**Re: Harnett County Land Use Application HTE #08-5-21354**

Based on the criteria set out in Title 15A, Subchapter 18A, of the North Carolina Administrative Code, Rules .1950, the evaluation indicated that the site is **UNSUITABLE** for the addition requested. Therefore, your request for an existing tank is **DENIED**. The site is denied based on the following:

UPDATED PLOT PLAN  
 235 PAPOOSE TRAIL  
 LOT 35  
 CHEROKEE RIDGE  
 HARNETT COUNTY, NC

UPDATED PLOT PLAN
 235 PAPOOSE TRAIL
 LOT 35
 CHEROKEE RIDGE
 HARNETT COUNTY, NC

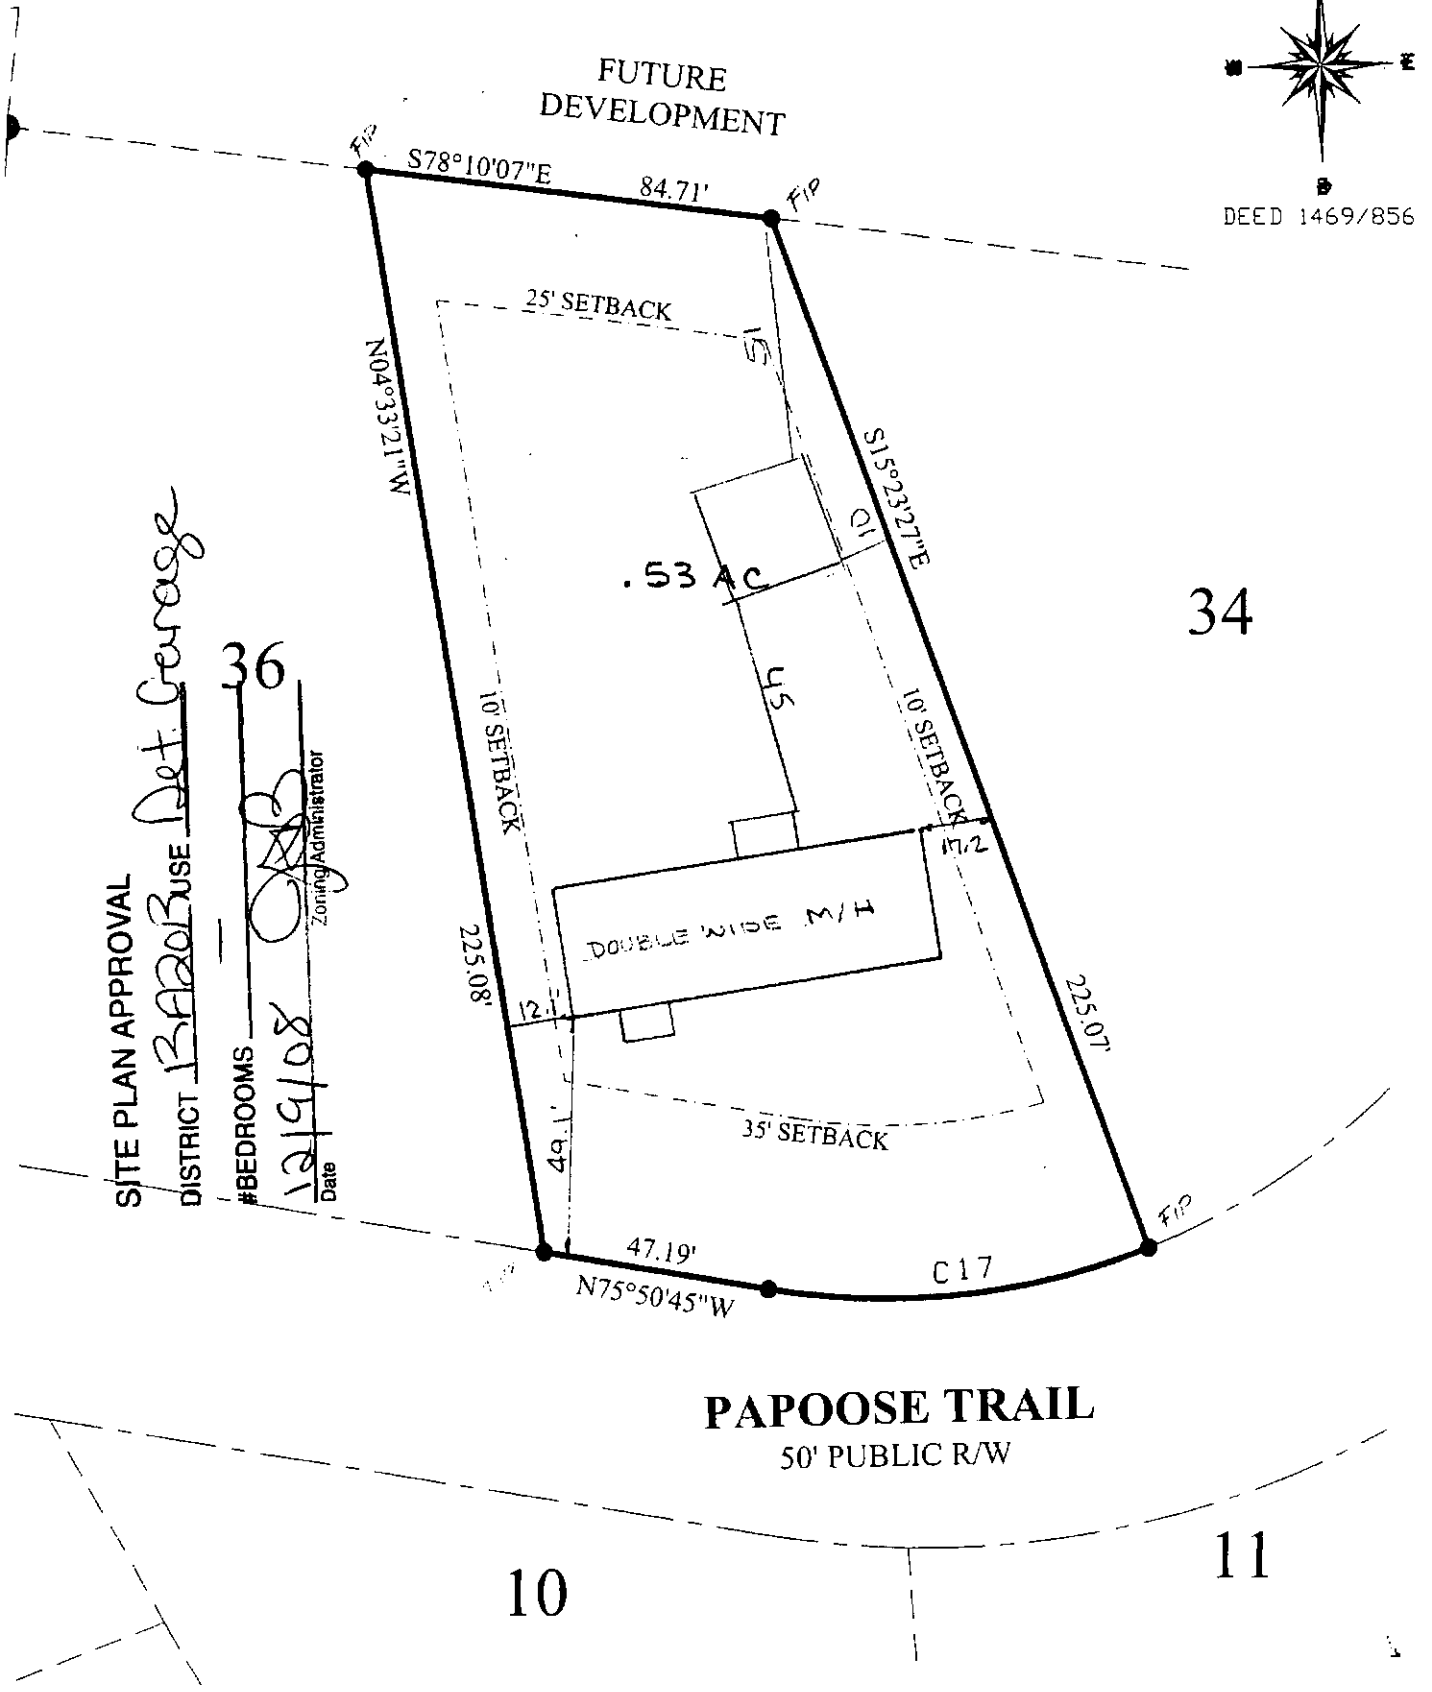
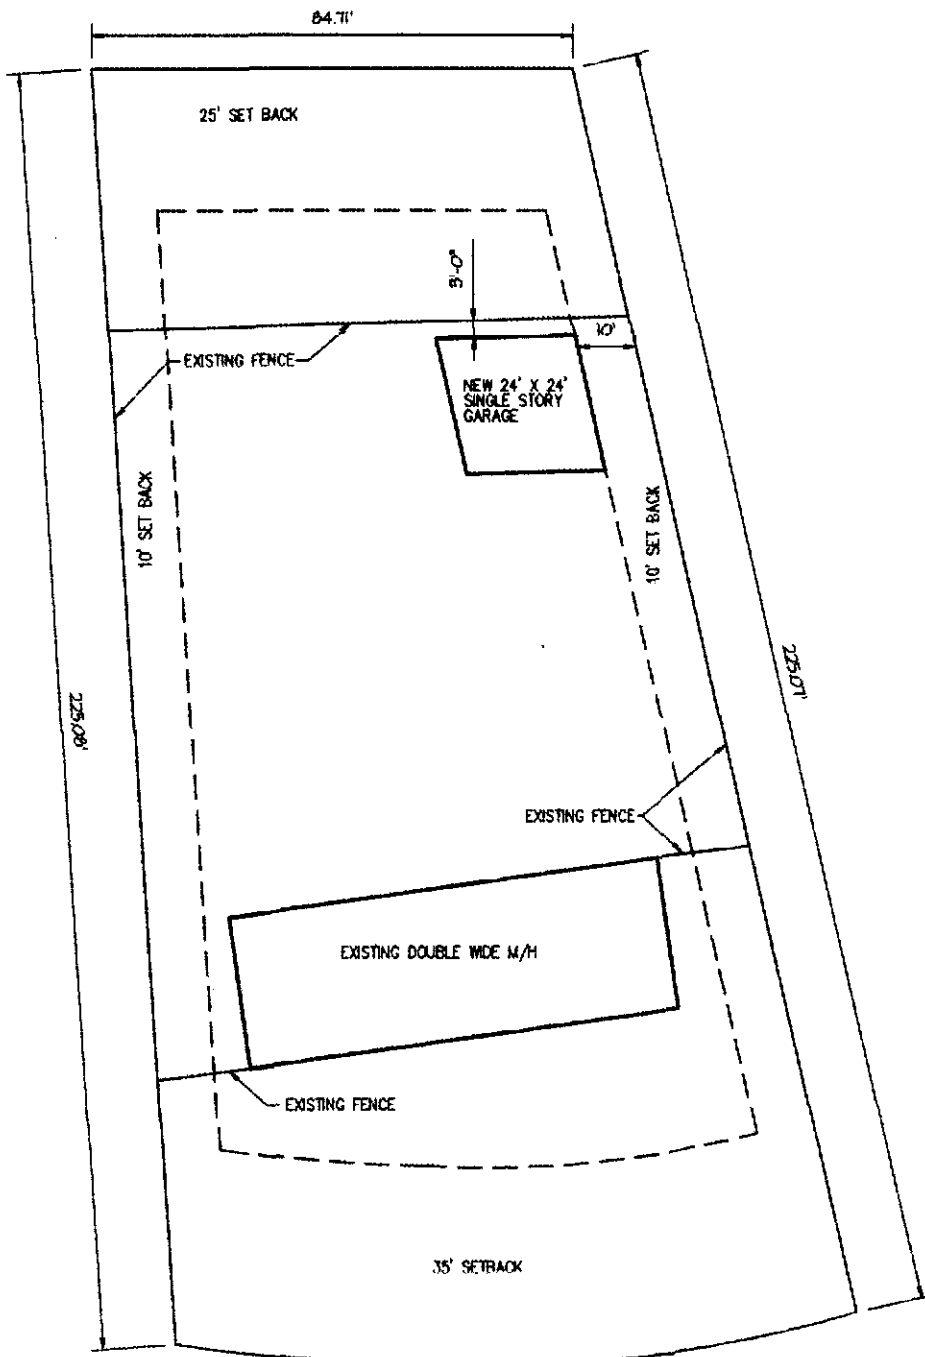
**15A NCAC 18A.1950 (10) – Any building to be 5' from drain line.**

***The garage is staked out on top of the drain field. (See the attached map showing approximate drain field and repair area location.)***
